NSW RURAL FIRE SERVICE

Your Ref: SSD 10353
Our Ref: D19/2187

Agency Comment - Proposed New Tweed Valley Hospital Stage 2 - Construction approval (SSD 10353); 771 Cudgen Road, Cudgen

Figure 77. Site Plan - Master-plan, Future Complementary Development (Artists Impression)

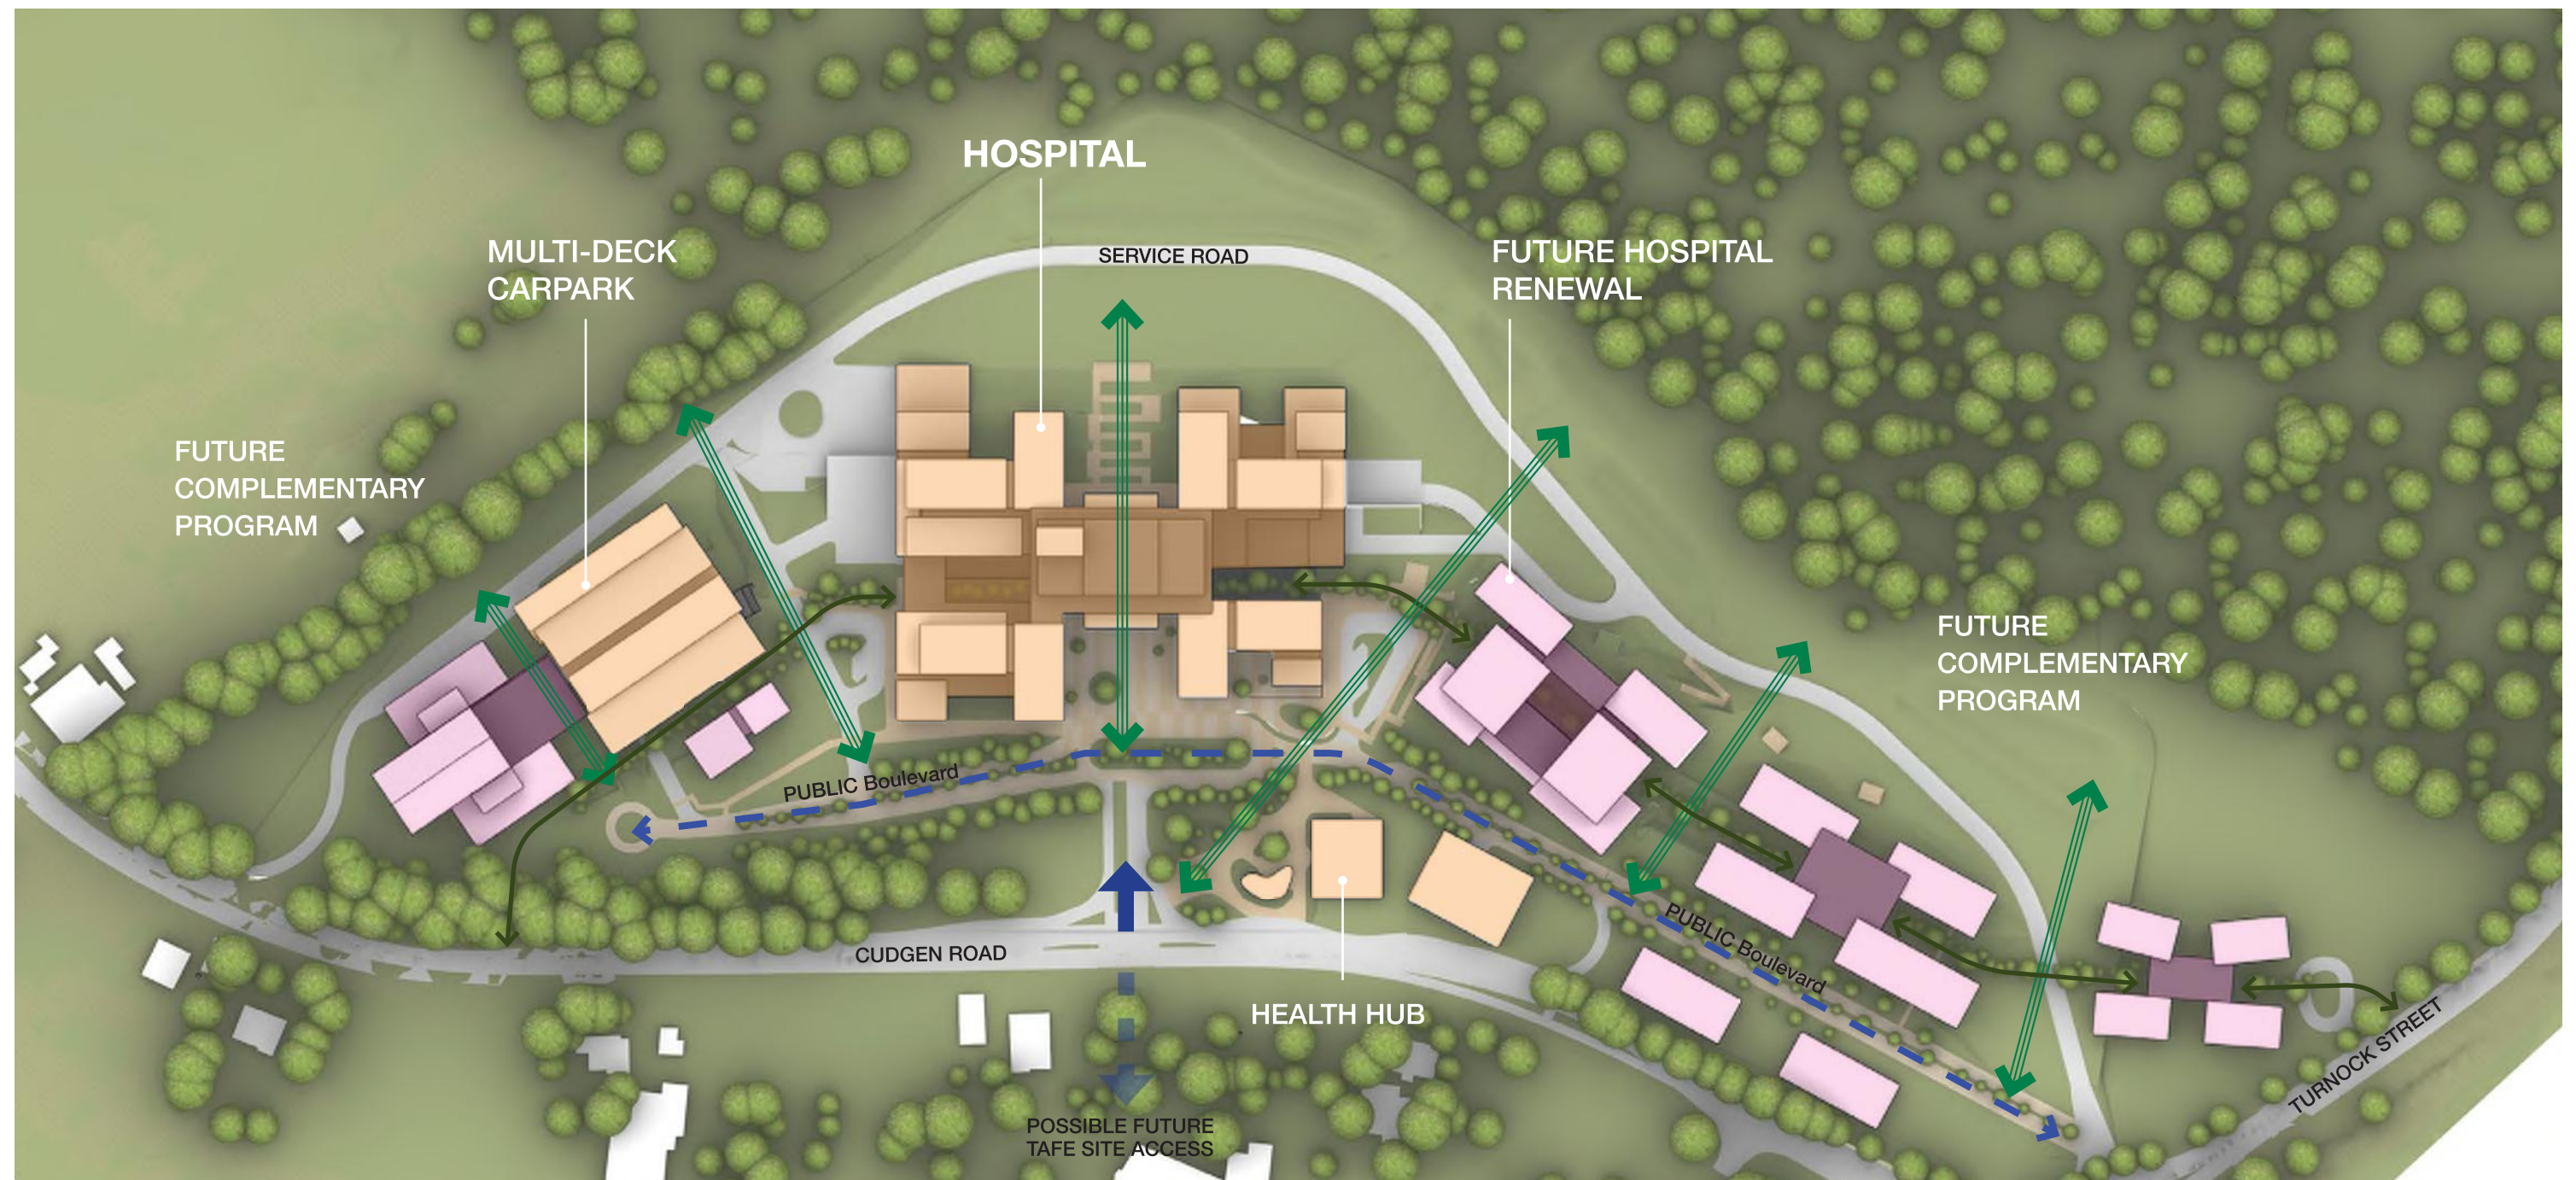
1. The development proposal is to comply with the Masterplan Plan-Concept Plan, prepared by STH Bates Smart for TSA Management numbered AR-SKE-10-006 revision 8 dated 11 September 2019.

2. At commencement of construction works and in perpetuity, the proposed asset protection zone (APZ), as identified in the Masterplan-Concept plan shall be managed as outlined within section 4.1.3 and Appendix 5 of 'Planning for Bush Fire Protection 2006' and the NSW Rural Fire Service's document 'Standards for asset protection zones'. The APZ can generally be divided into a 47 m inner protection area (IPA) and 20 m outer protection area (OPA).
